Date: 4 April 2019

**Application by Horizon Nuclear Power for an Order Granting Development
Consent for the Wylfa Newydd Project**

Change to the original application.

Change Request relating to the proposed Dalar Hir Park and Ride

Scale	AS SHOWN	Sheet Size	A1	Sheet(s)	1 of 1
Drawing Number	WN0902-HZDCO-ADV-DRG-00032				Rev
				1.0

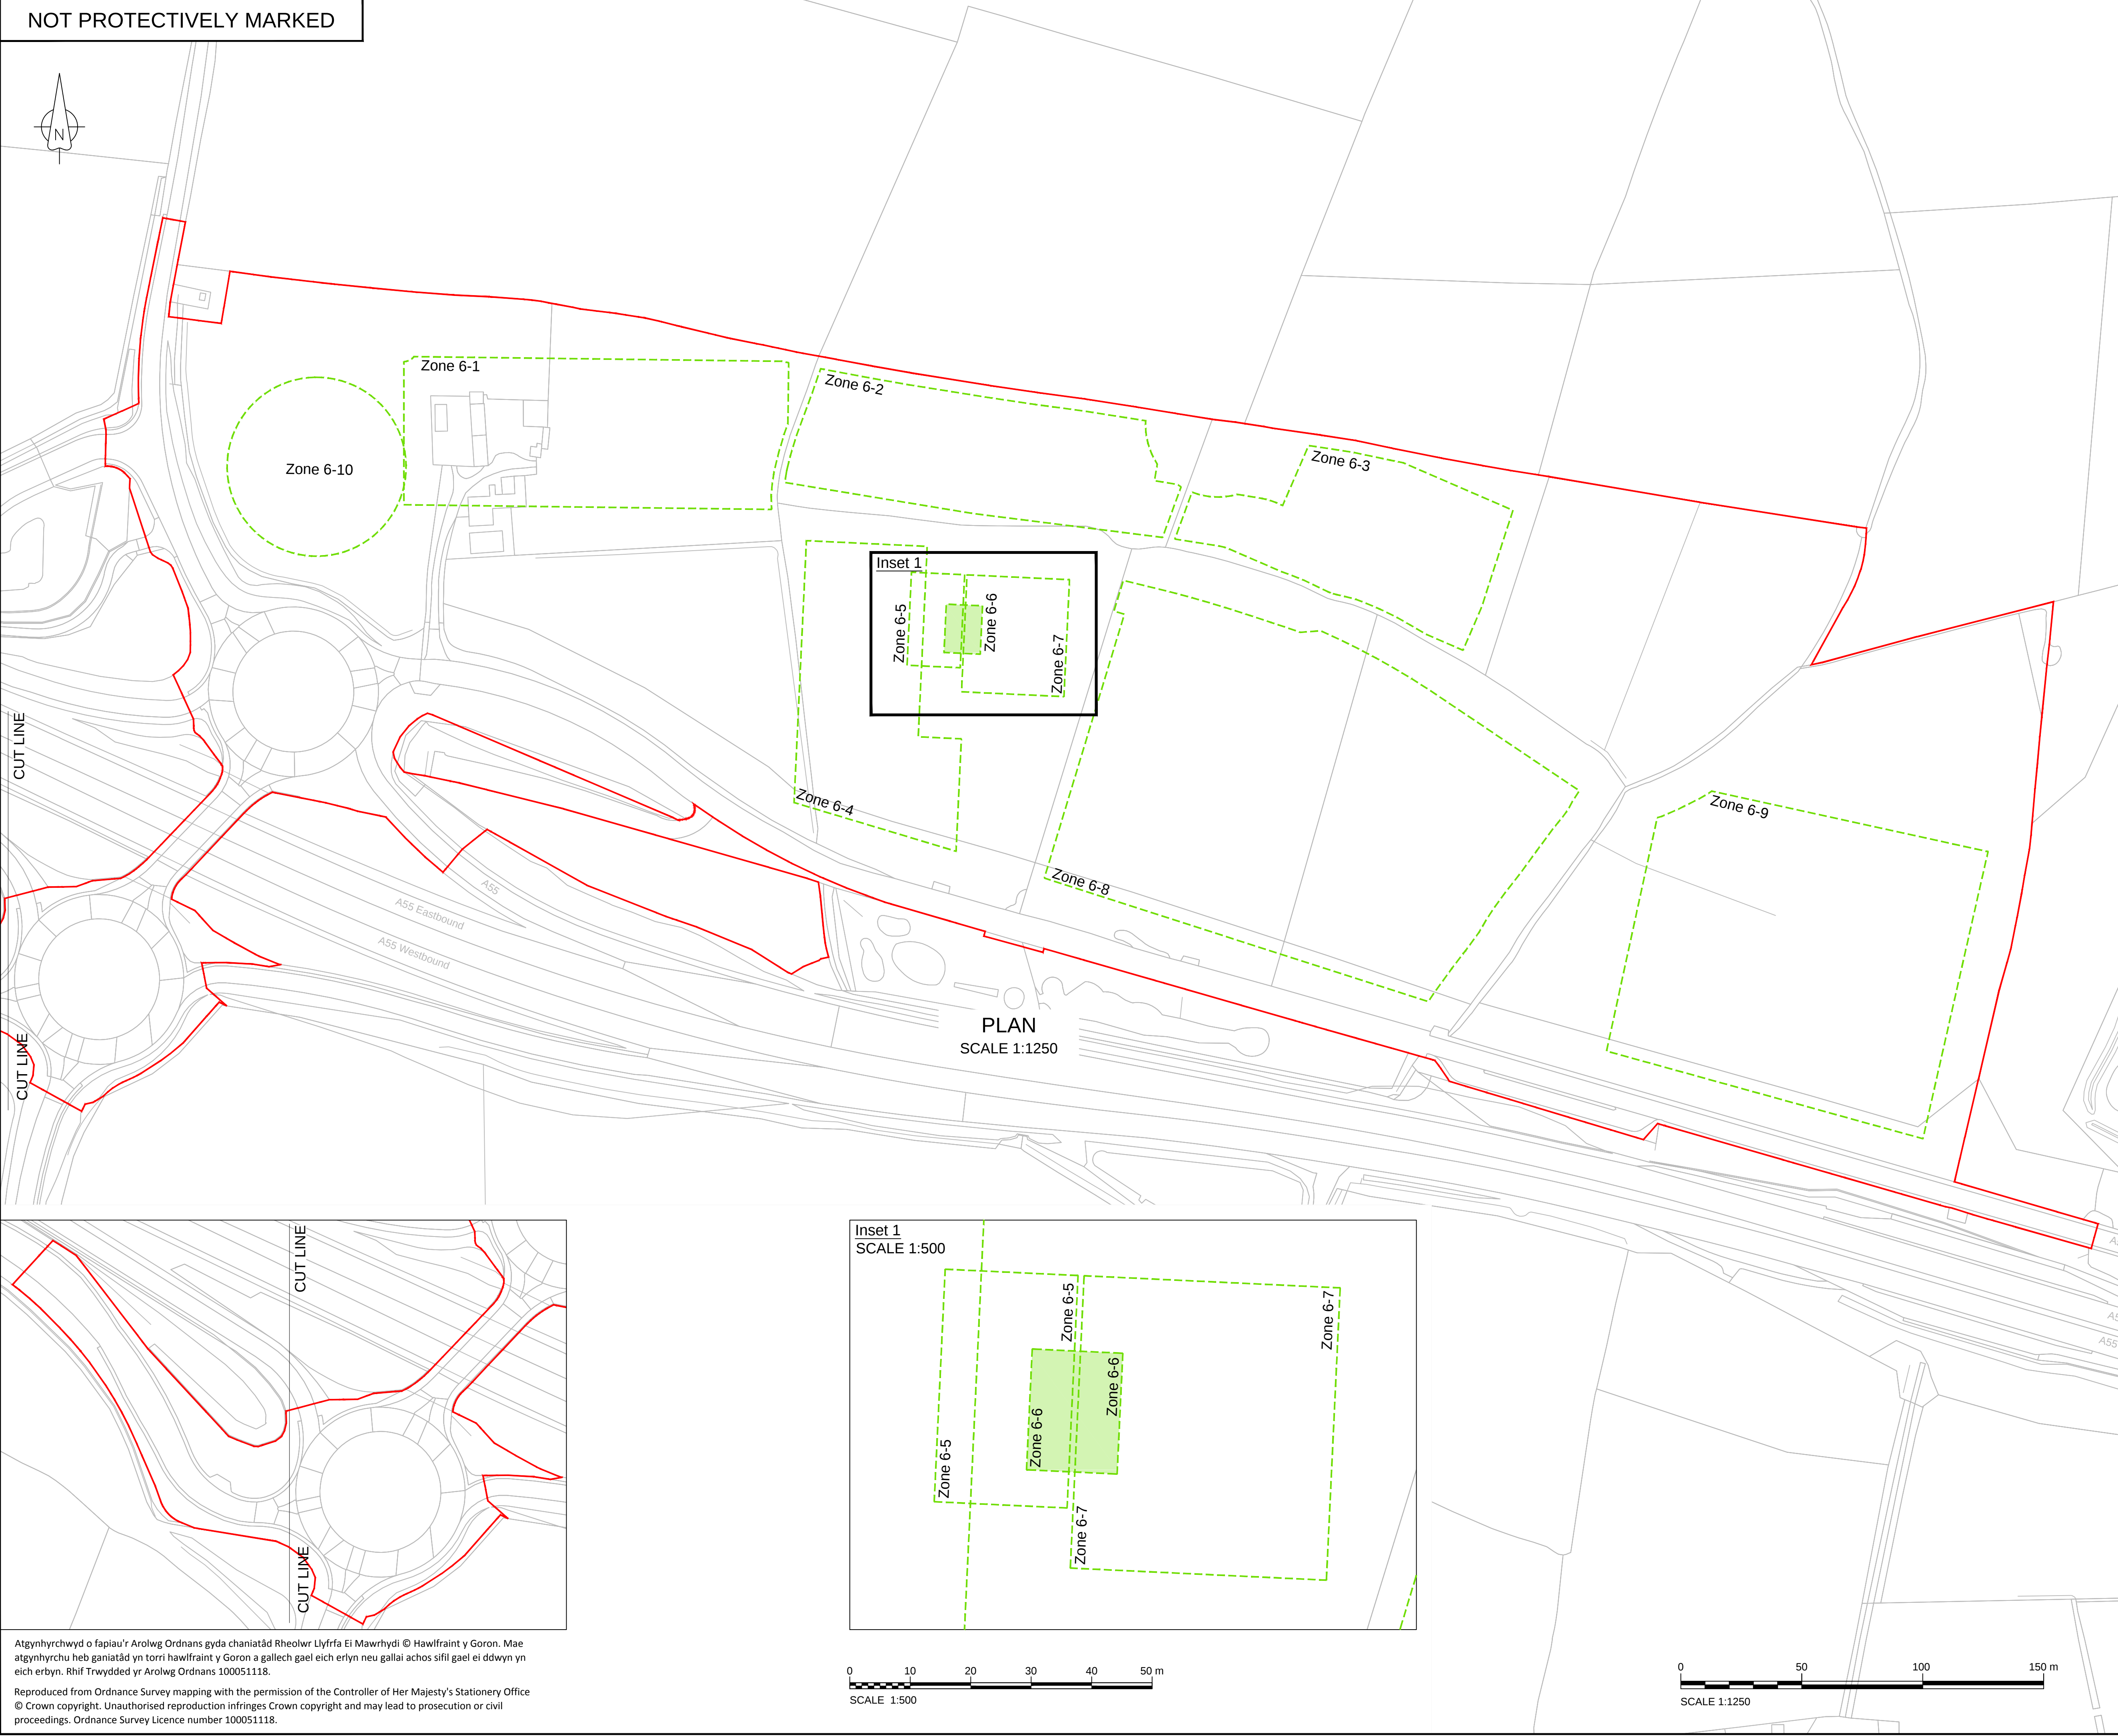
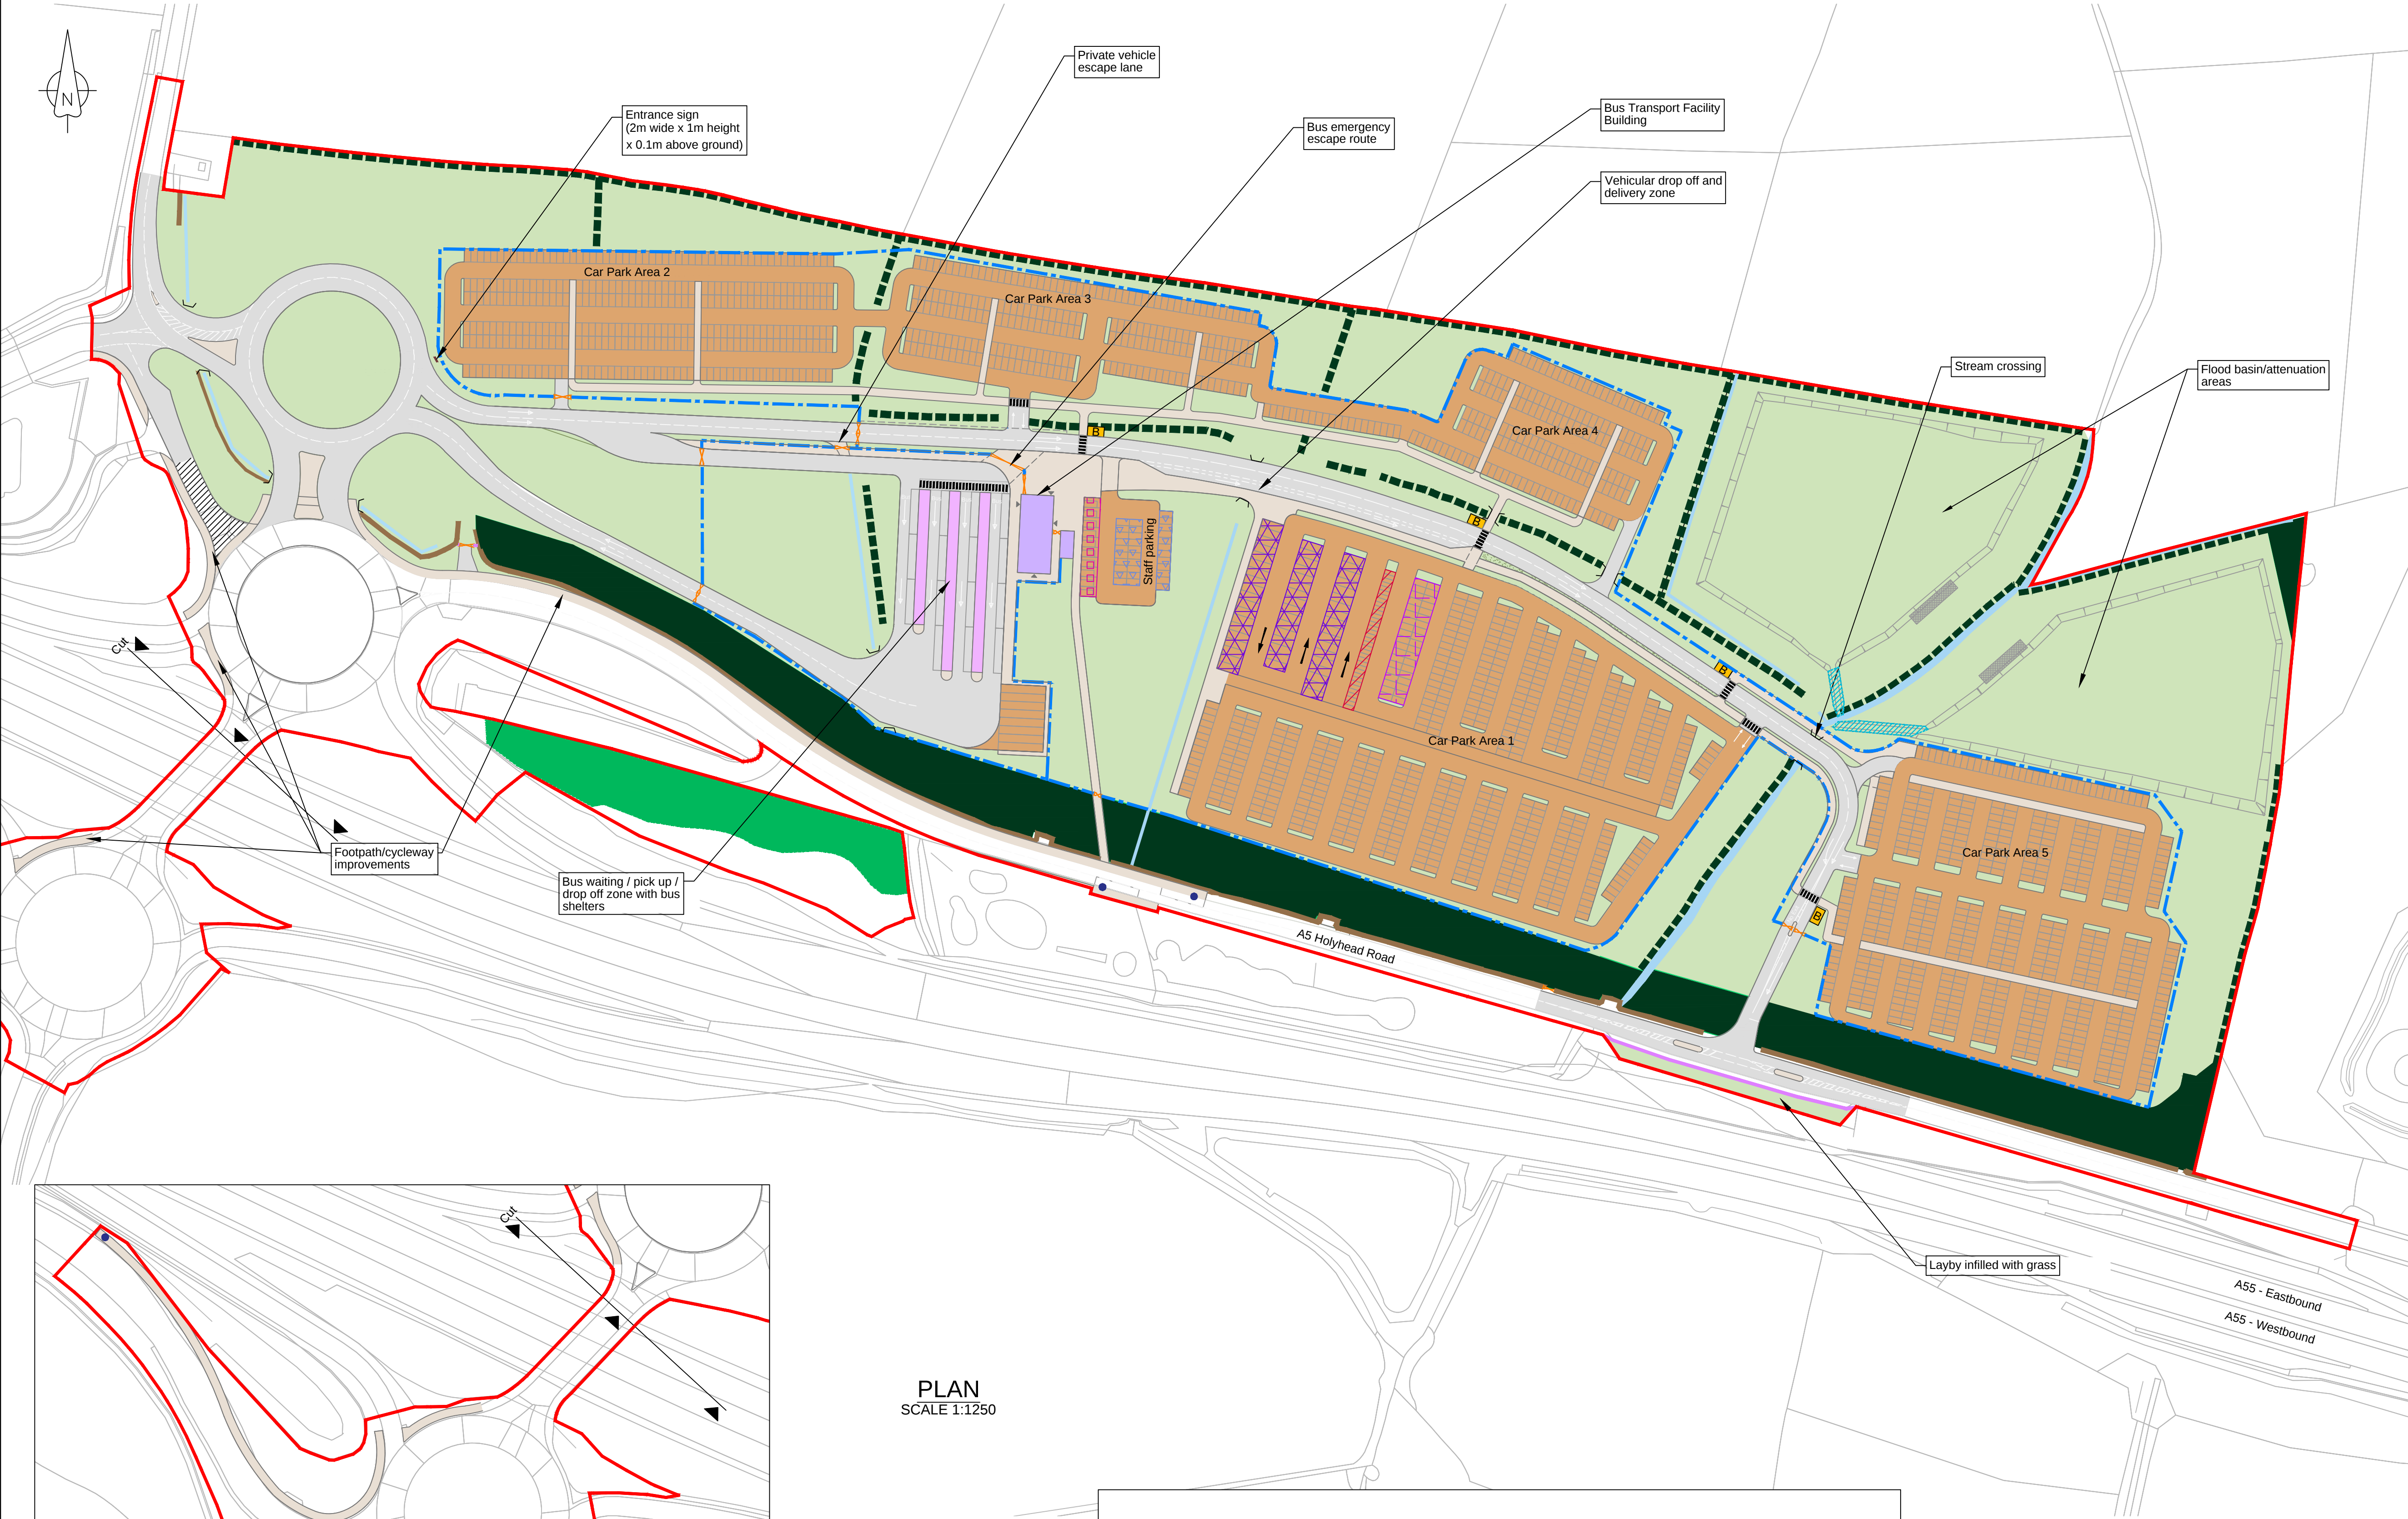
- Removal of the internal roundabout at the entrance to the proposed site of the Park and Ride at Dalar Hir and replacement with a single arm from the existing A5 roundabout at the A5/A55 dumbbell junction (Junction 4)

The access to the Park and Ride, as shown in the application as submitted, involved changes to London Road and the introduction of a new roundabout. The Highways Authority (Isle of Anglesey County Council – IACC) considered that the proposal would compromise forward visibility on the approach to the London Road such that it would not have complied with standards from the Design Manual for Roads and Bridges (DMRB). The proposed design amendment would obviate the need to make changes to London Road and the existing highway network would remain in its current form and comply with standards set out in DMRB. Consequently, existing users would continue to use the road in its current form. The proposed use of a single arm from the existing roundabout is considered by both the Applicant and the IACC to reduce the interface of traffic with non-motorised users crossing the revised junction and fewer construction and operational vehicle movements on the existing highway.

Accordingly, the ExA agrees that the change to the application's access arrangements for the proposed Dalar Hir Park and Ride Site would be a non-material change to the application and that it should be accepted for consideration in the examination as part of the application.

From representations made at the Issue Specific Hearing on 7 March 2019, it is evident that IACC as the Highways Authority consider the proposed amendment would address their concerns regarding highway safety. The amendment would result in the retention of the existing road layout, albeit with a new access/egress being created off the existing roundabout. Nonetheless, the effect of the revised access/layout on traffic flows and highway safety will be considered fully by the ExA as part of the examination.
